Figure 2
Site Plan

LSC Responses to TIS Redline Comments

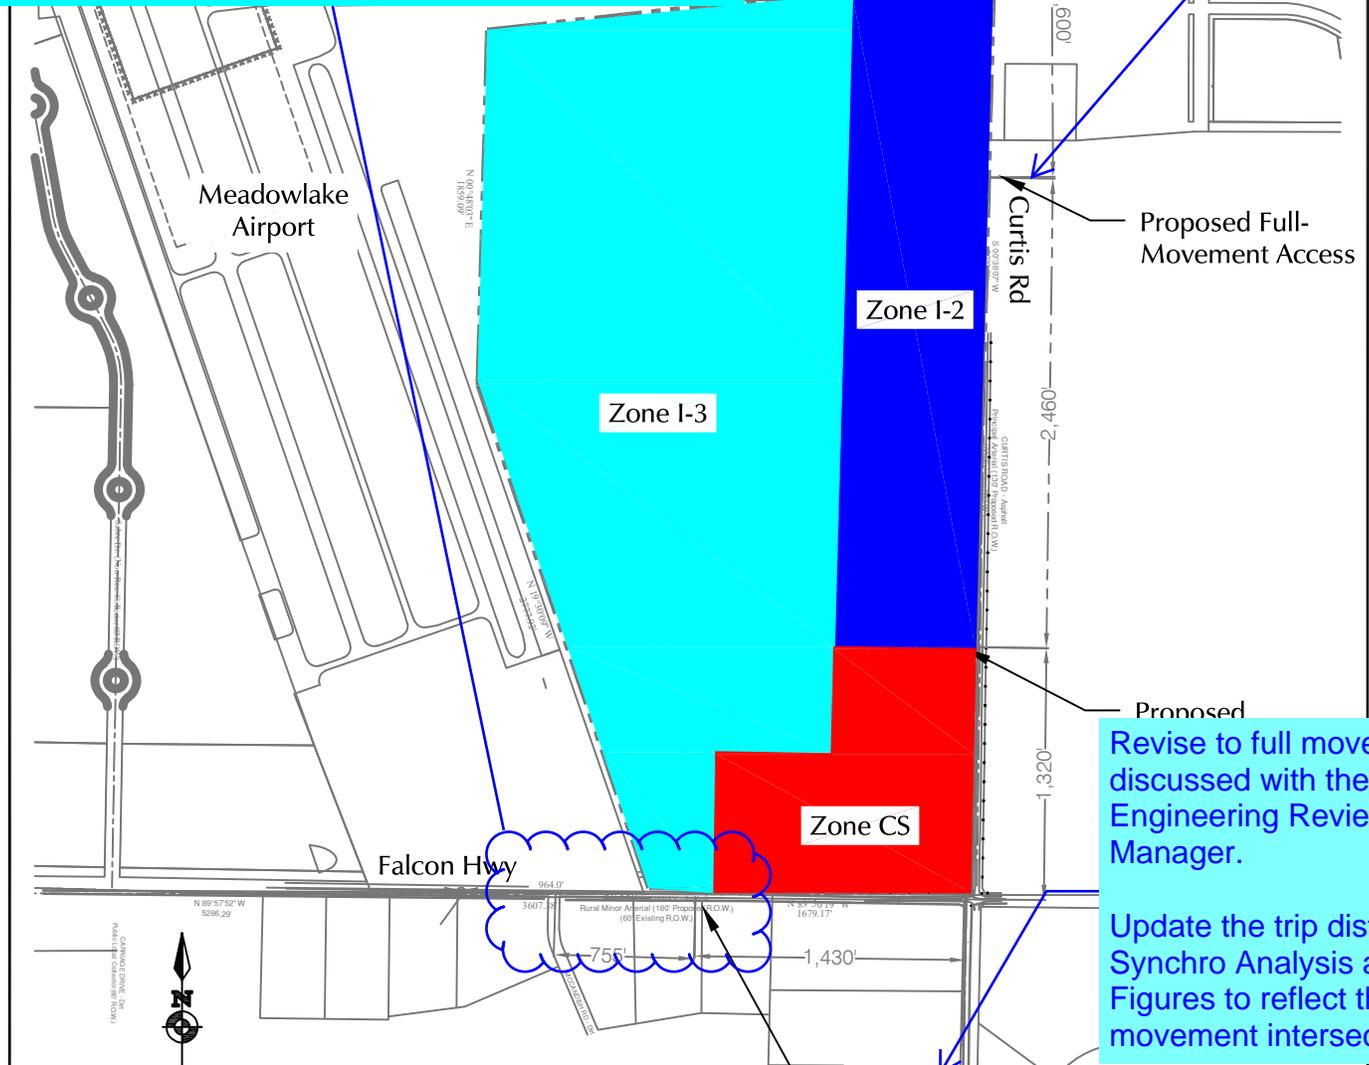
Update the conclusion/recommendation to identify that a deviation request for intersection spacing will need to be submitted on the subsequent preliminary plan application.

With over 6,000 additional trips placed on Falcon Hwy should a WBLT be added at the McCandish Rd intersection? Either update the TIS to provide the impact analysis and recommendation at the Falcon Hwy and McCandish Rd intersection or state in the conclusion/recommendation that said analysis will be provided in the TIS submitted with the preliminary plan application.

Update access location consistent with the directions provided by the Engineering Review Manager. (1/2 mile north of Curtis & Falcon intersection)

Proposed
Revise to full movement as discussed with the Engineering Review Manager.

Update the trip distribution, Synchro Analysis and Figures to reflect the full movement intersection.

LSC Response: The TIS has been revised to state in the conclusions/recommendations section that a deviation request for intersection spacing to the McCandish Road intersection will need to be submitted with the subsequent preliminary plan application. The report also states that the potential need for a westbound left turn lane on Falcon Highway at McCandish Rd intersection will be evaluated and analysis will be provided in the TIS submitted with the preliminary plan application. Note: it is unlikely that the ECM turning volume threshold for a westbound left turn lane lane will be exceeded, however the evaluation will consider other factors including the detailed eastbound left turn lane geometry needed for the site access on Falcon Highway, including redirect tapers, as well as sight distance, grade, the crest vertical curve geometry on Falcon Highway, etc.

LSC Response: The TIS has been updated per this comment.

LSC Response: The access to Falcon Highway needs to remain a 3/4 movement intersection due to substandard sight distance to the west (for trucks). The TIS continues to show the 3/4 movement configuration. The deviation for the Curtis Road access has been revised to include discussion of the sight distance limitation at the Falcon Highway access.
